**Our Ref: BR/157/13/
Your Ref:**

**Town & Country Planning Act 1990 (as amended)
Town and Country Planning (Development Management Procedure) (England) Order 2010 (as amended)
Application for Planning Permission**

Development Proposed french doors with glass juliet balcony with glass balustrade
Location 6 The Gables Norfolk Square Bognor Regis

block plan

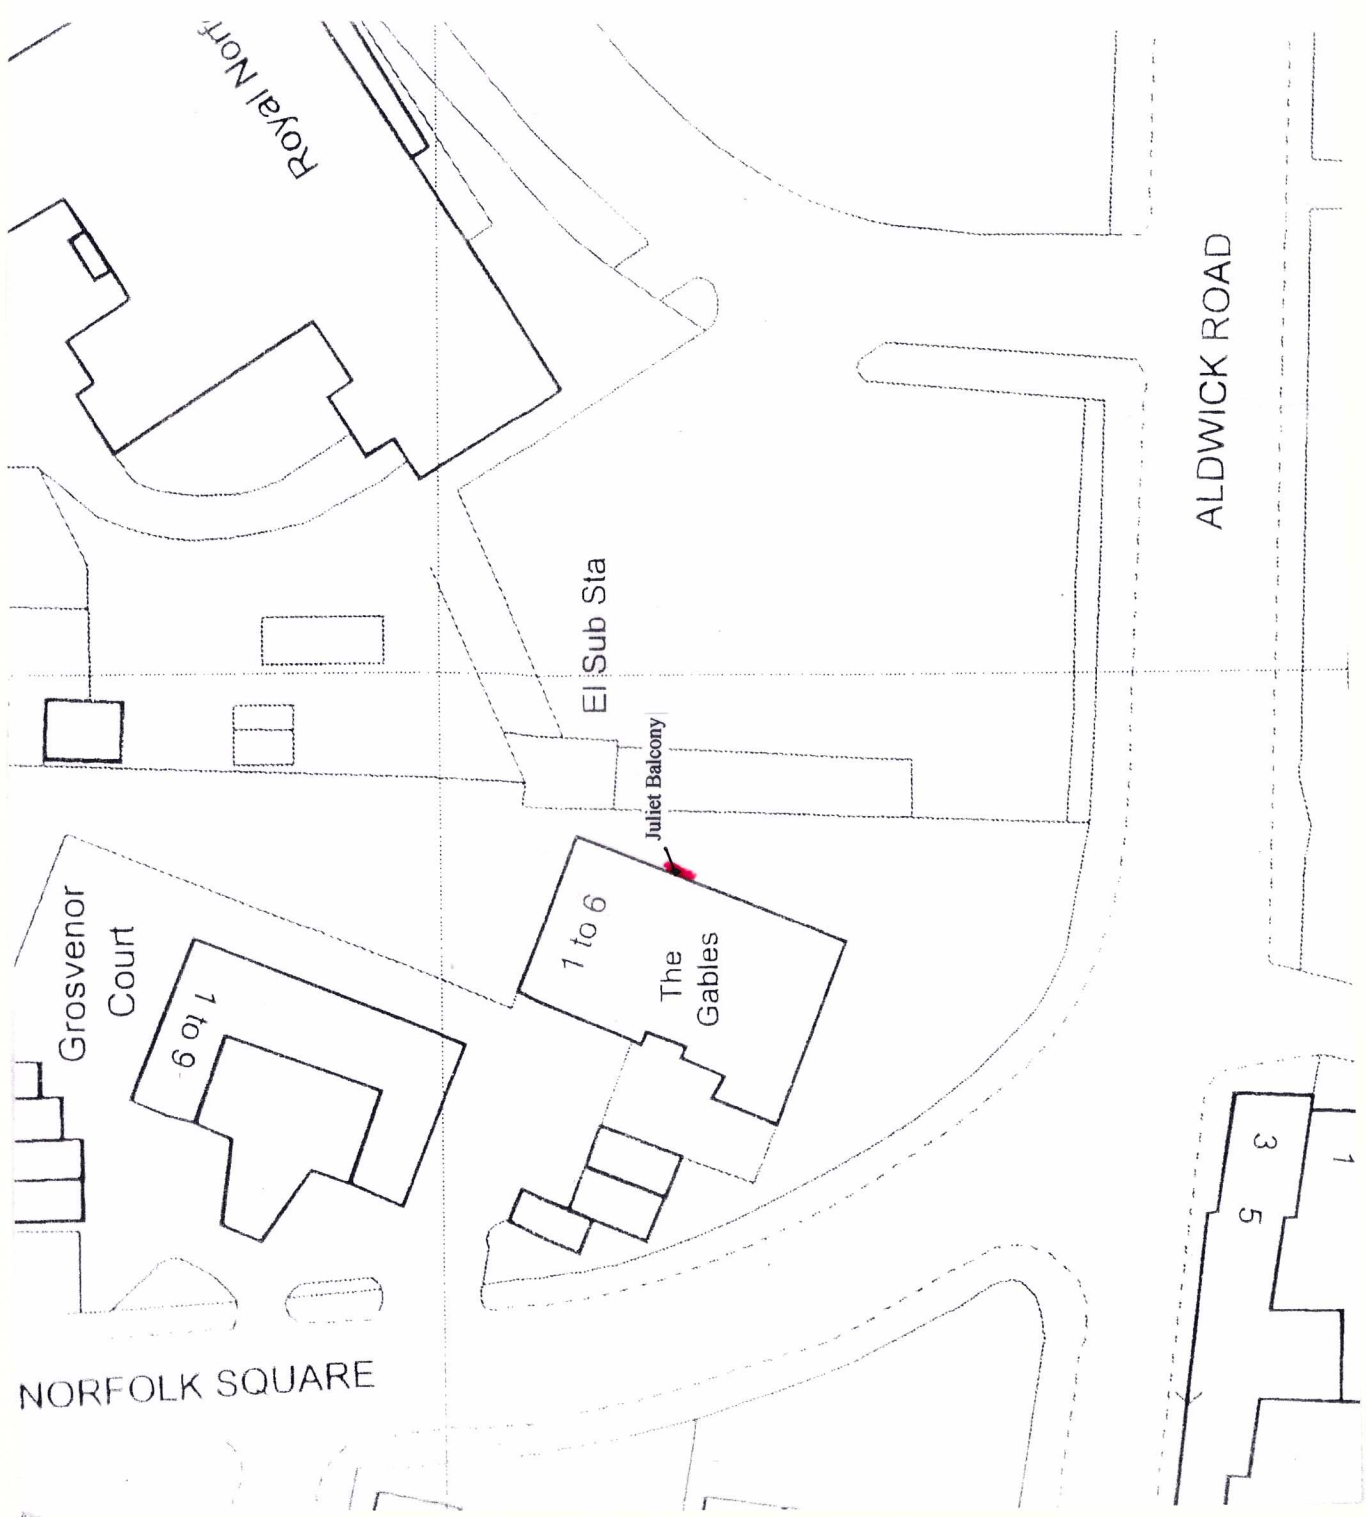
Block Plan

Please submit 1 electronic or 3 paper copies of a revised block/site plan with the proposed balcony clearly indicated at a scale of 1:500 or 1:200. Further details of what must be included on the plan can be found in the National Validation Requirements.
